From: Mark Taylor [REDACTED]
Sent: 24 January 2022 15:26
To: Planning.Responses [REDACTED]
Subject: Re: Request for further information A/9/22/CLP FAO Nicola Moore

South Elevation

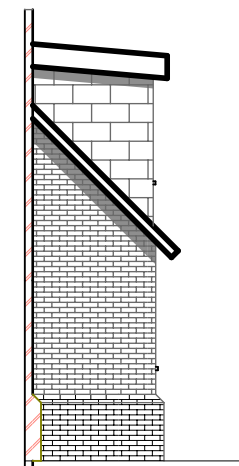
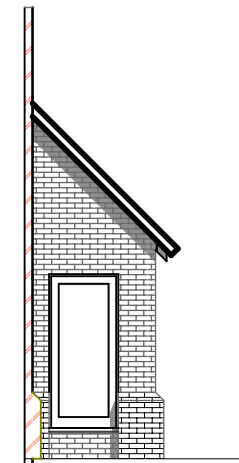
Just to clarify there is an existing door on the south elevation which is to be removed. There was an existing line of plinth work which will be extended to fill the door aperture.

Please find attached a revised copy of our drawing clarifying this.
